KITTITAS COUNTY

TO: Jeff Watson, CDS
FROM: Christina Wollman, Planner II *CW*
DATE: September 27, 2013
SUBJECT: Haw BL-13-00023

Re: Haw (BL-13-00023)

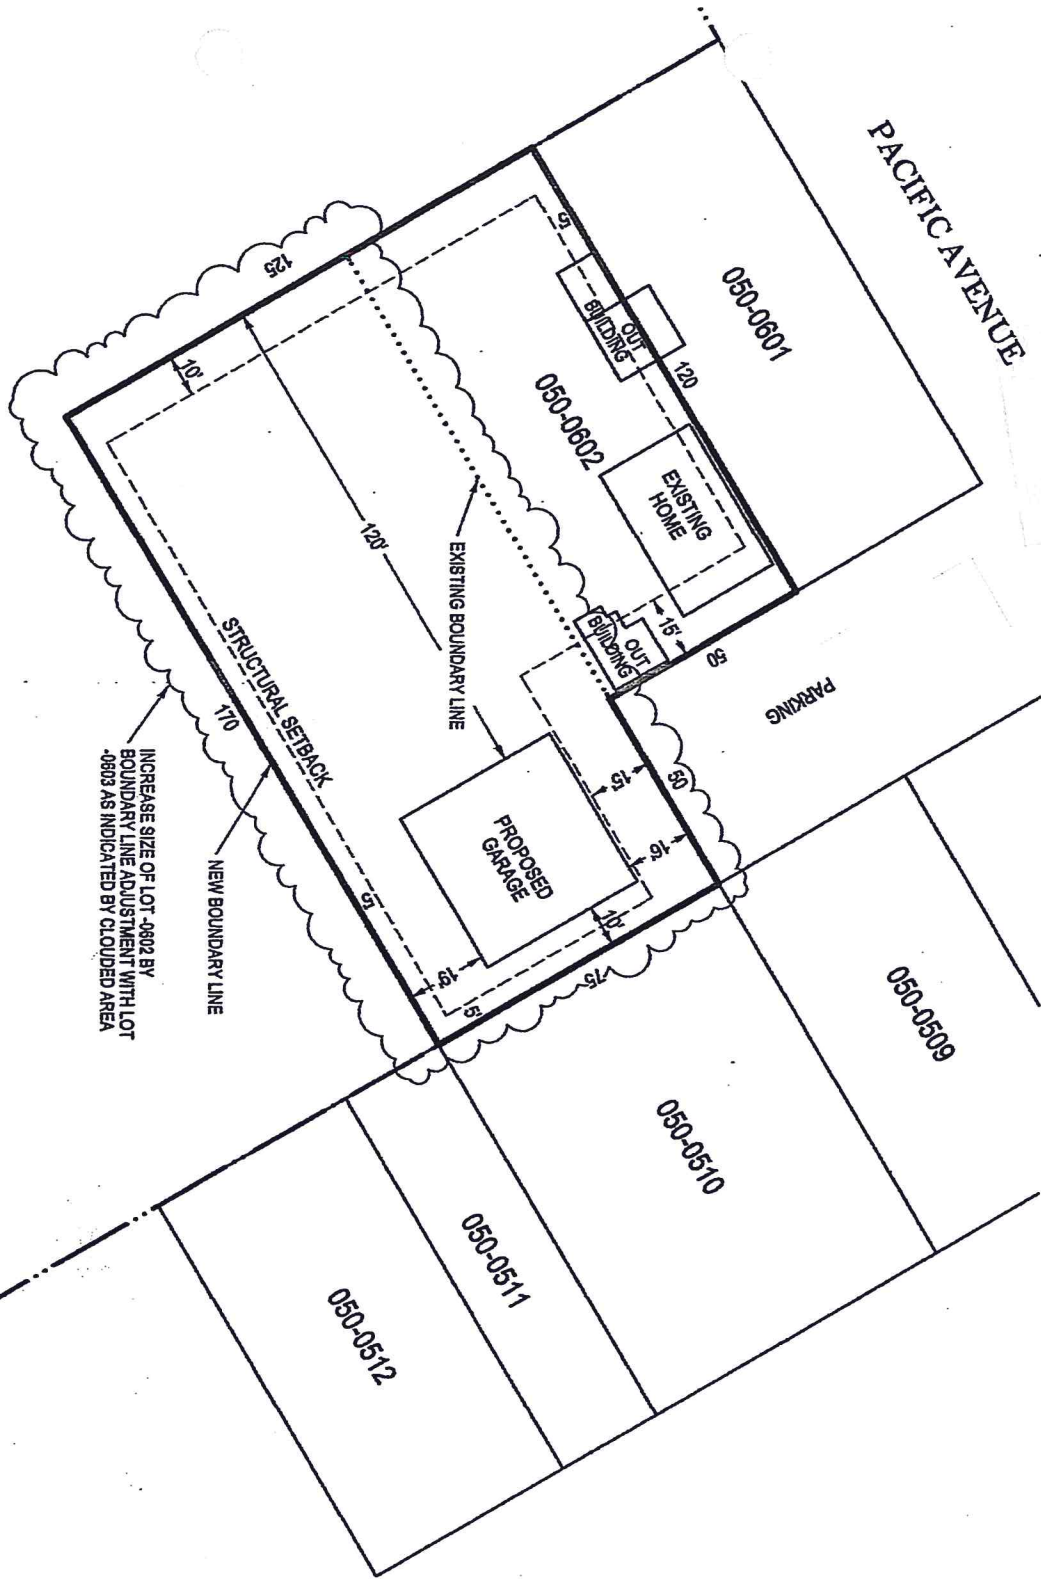
Being so closed to Ronald, I cannot determine whether the property is served by sewer and water from the city... I think there is a need for a section in the application that asks existing / proposed sewer and water source.

The site map makes no reference.
